Your ref: SSD-86969958
Our ref: DOC26/105809

**Subject: Environmental Impact Statement – St George Private Hospital Expansion
(SSD- 86969958)**

CPHR advice on EIS - St George Private Hospital Expansion (SSD-86969958)

Figure 12: 1% AEP Overland Flow Depths - Future Climate (*Draft Blakehurst and Kogarah Bay Wards Overland Flow Flood Study*)

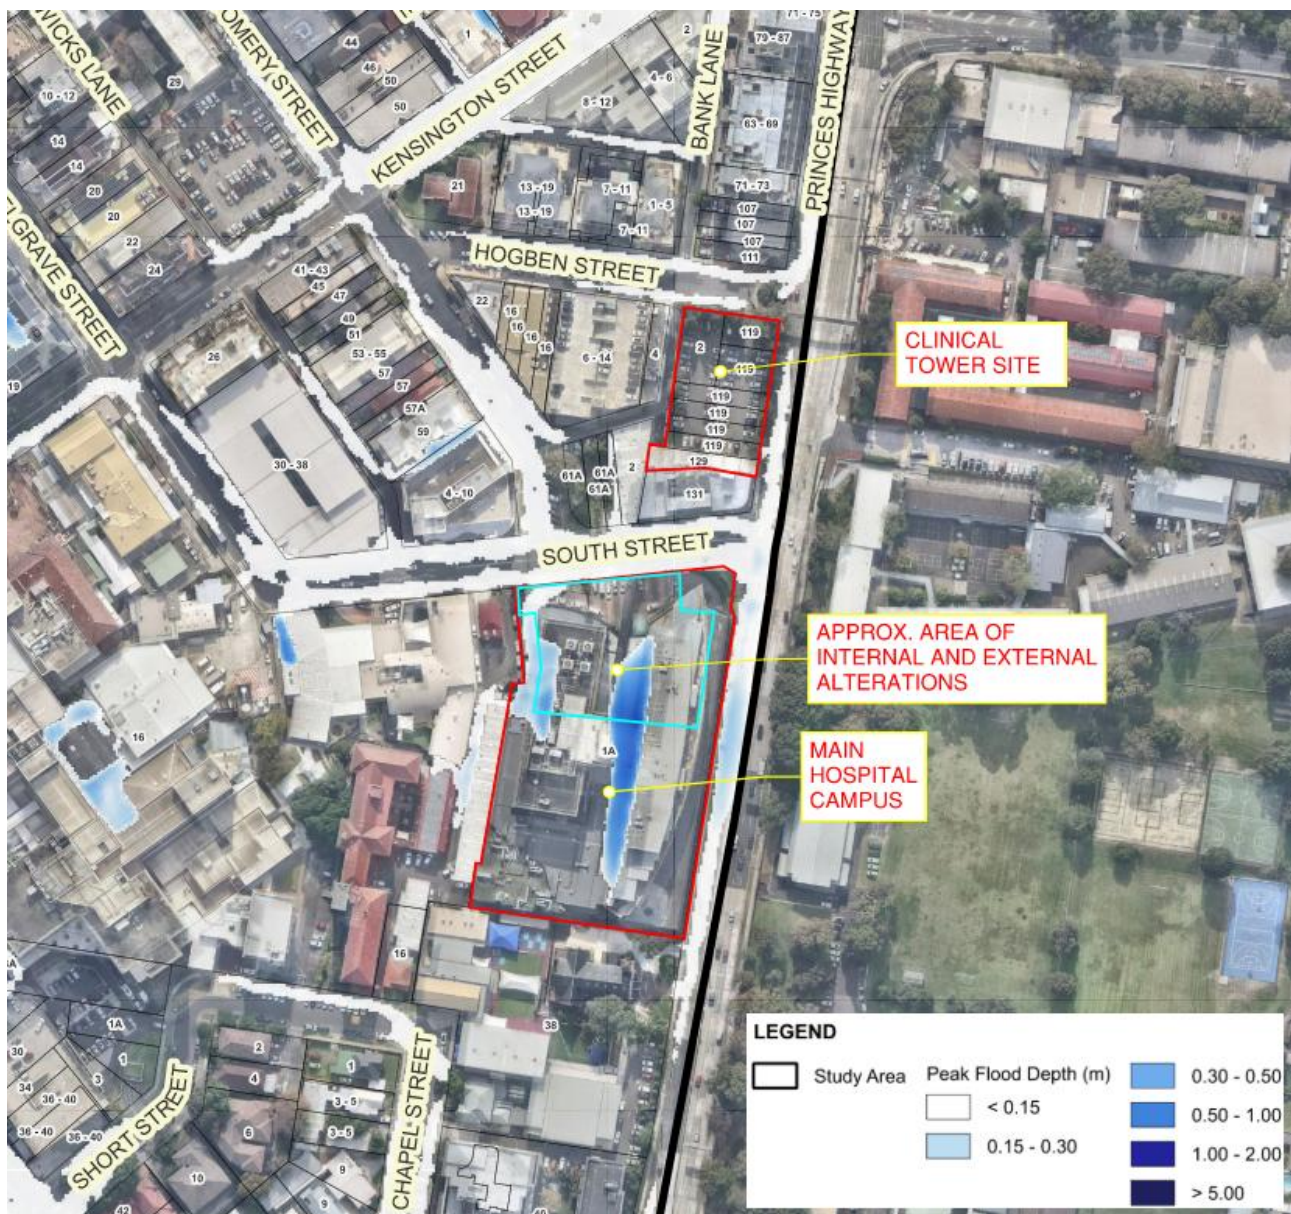
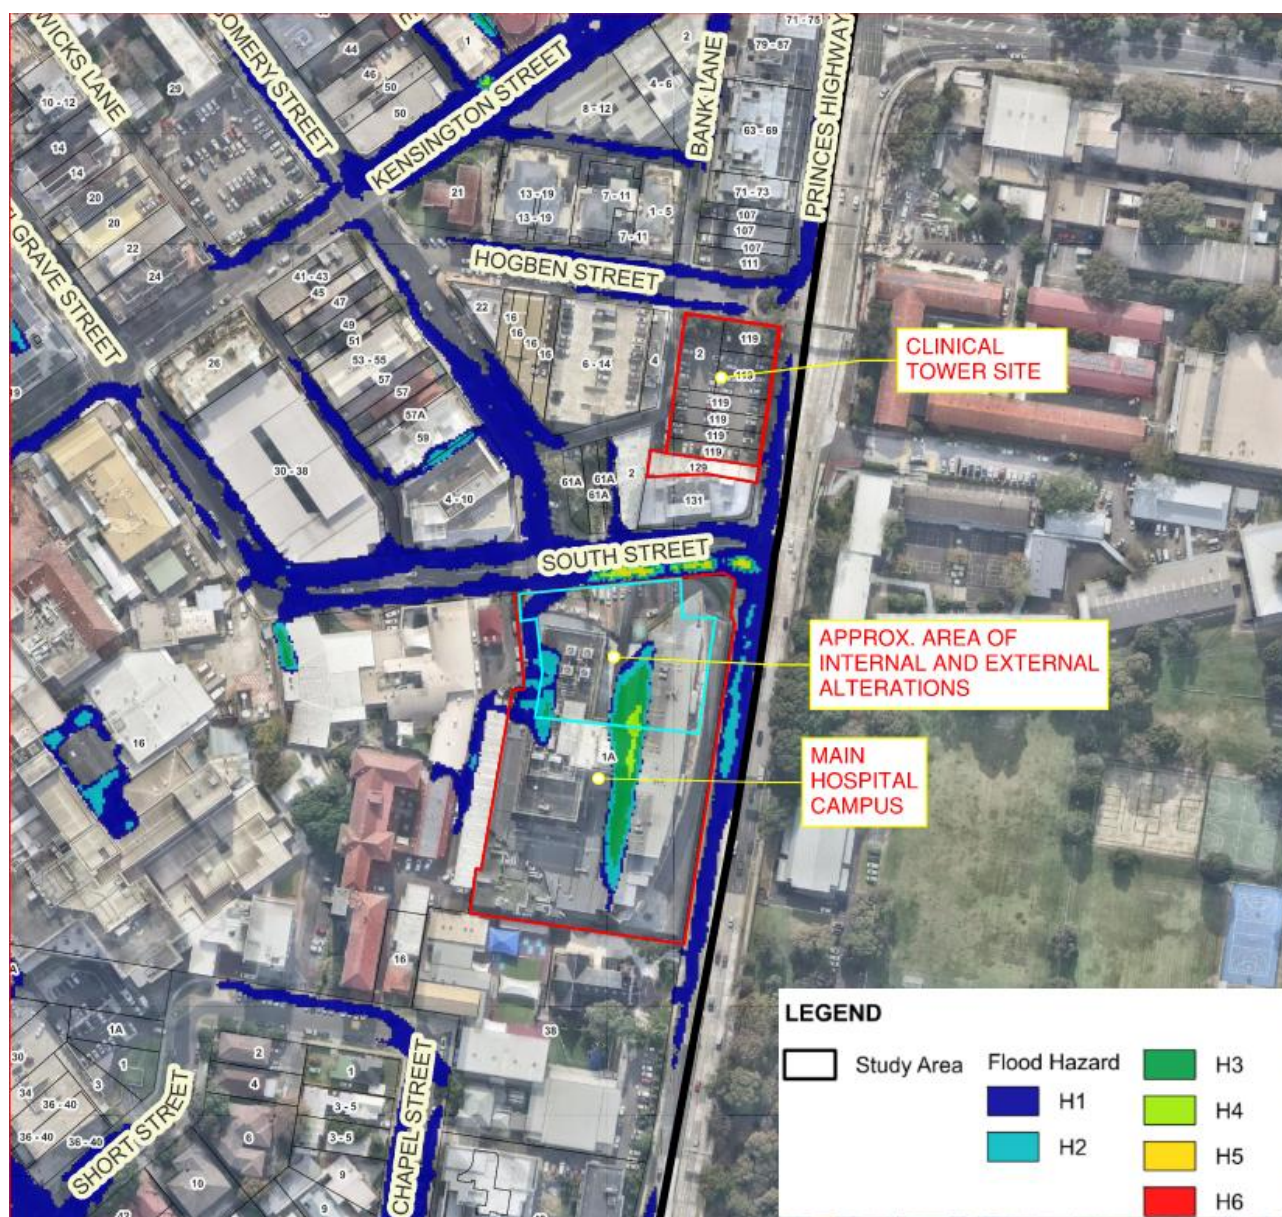
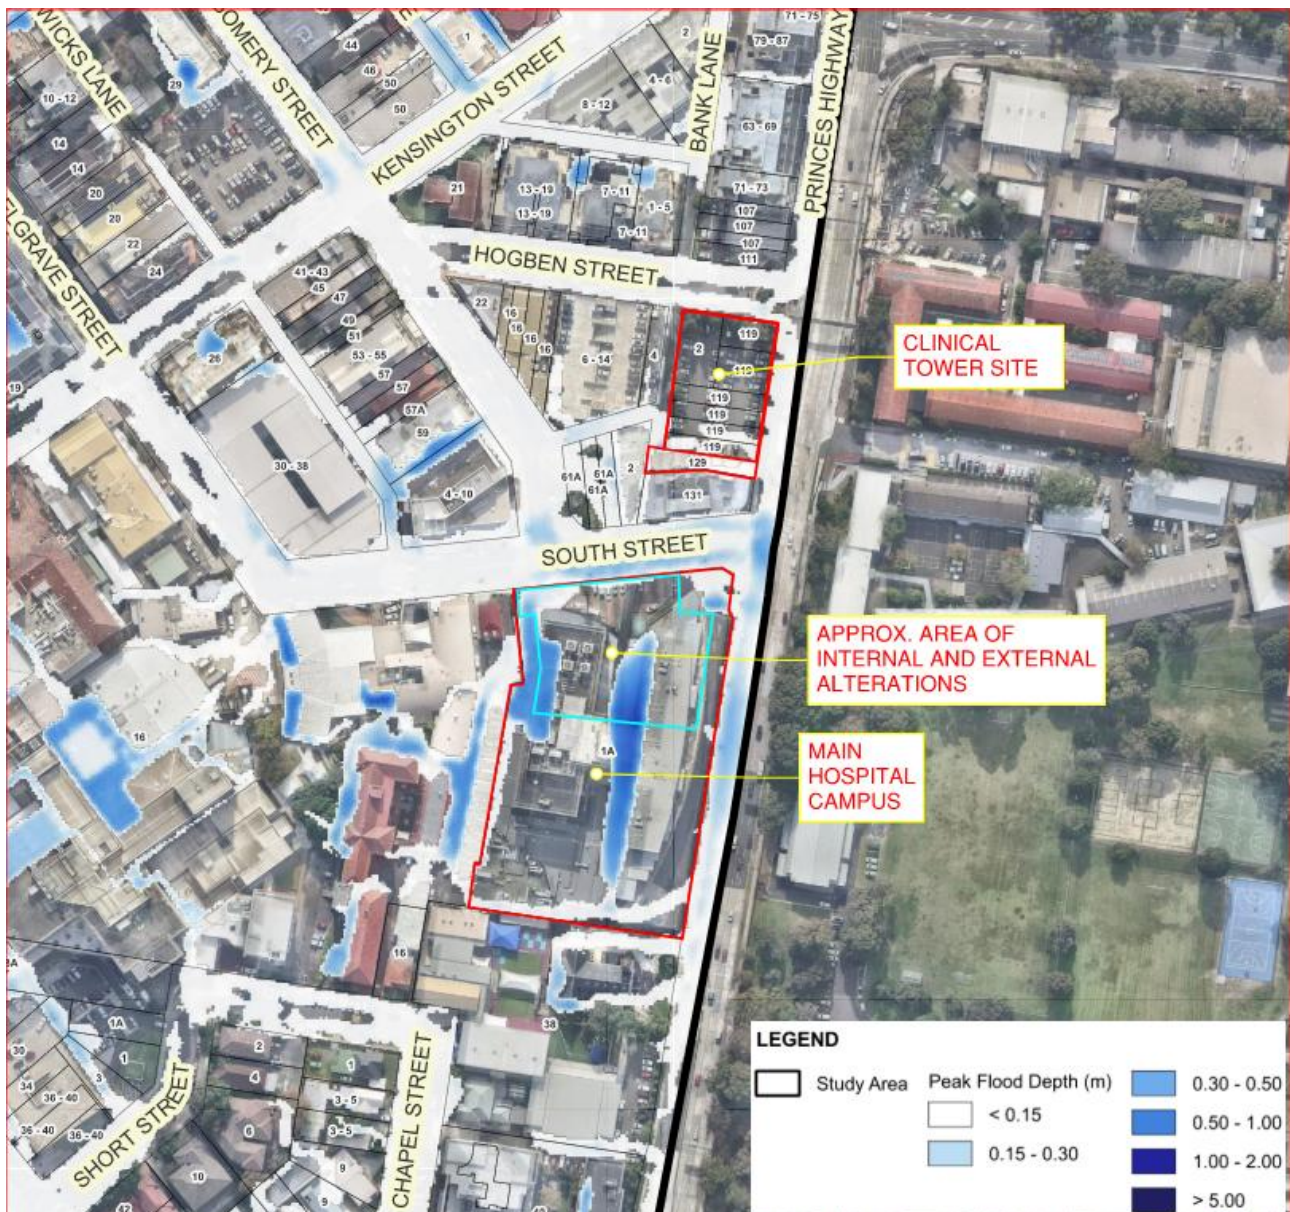
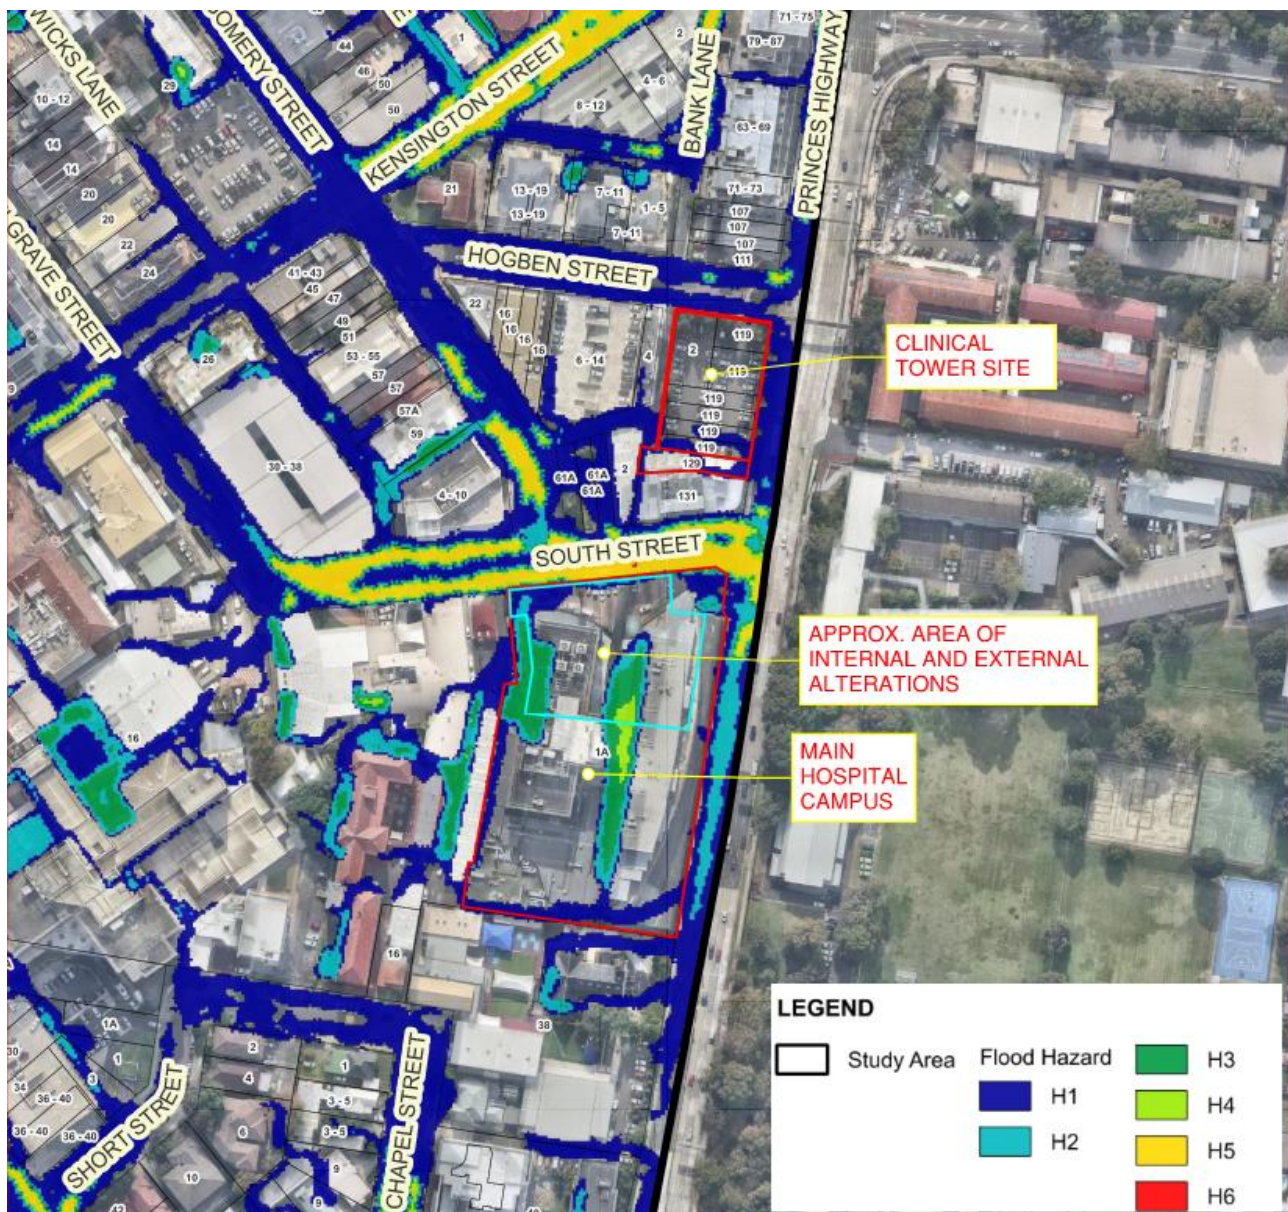
2	<i>Fit for purpose Flood Impact and Risk Assessment (FIRA)</i>	The proponent has not satisfactorily addressed the SEARs requirements to identify: - flood planning levels (FPLs), - on-site flood risks, and - potential effects of climate change. The FIRA relies on mapping from the Draft Flood Study rather than undertaking project-specific modelling. Given the scale of the proposed hospital expansion and the fact that the Main Hospital Campus is located within a high-risk flood precinct for critical uses, this reliance is not considered fit-for-purpose. In particular, it does not adequately: - set accurate FPLs for the Main Hospital Campus ground floor or for the crest of the Clinical Tower basement carpark - assess the potential impacts of blocking the overland flow path between Bank Lane and Princes Highway - estimate warning times and response times required to inform emergency management planning. If the proponent intends to continue relying on the Draft Flood Study, they must first verify that site-specific hydraulic features, such as pits, pipes, kerb and gutter profiles, and other key flow controls, are accurately represented. Recommended action: Prepare a fit-for-purpose hydraulic model and submit an updated FIRA in accordance with the Flood Impact and Risk Assessment Flood Risk Management Guideline LU01 (NSW DPE, 30 June 2023).
